Subject: F.W. Norton Farm House - AL/35/20/12 & AL/35/20/13 - PRE COMMENCEMENT

EAST ELEVATION TO COURTYARD

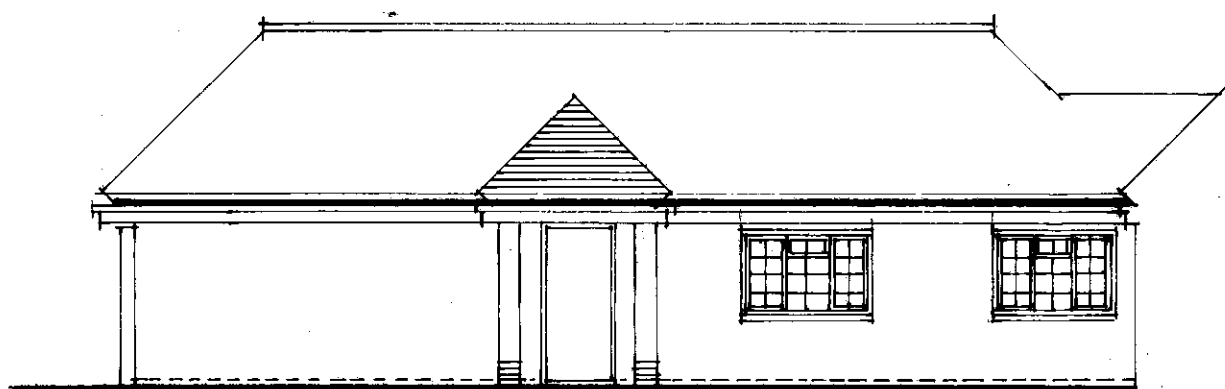
Both myself and the Conservation Officer have picked up on the fact that the East Elevation is not correct – the 2 windows shown do not match the site photos provided – the drawings show 3 bay windows, the photos clearly show single bay windows (and for conservation purposes should stay as such). Please also add annotations to the new entrance door and existing double timber doors to the workshop to state these will be timber (as at the moment they could be seen as glazed). Please also add red bubbles around each of the proposed changes so all is clear. With the existing and proposed all on one sheet at present it is not clear at all.

Please amend the Elevation sheet and send to me by next Tuesday 7th July.
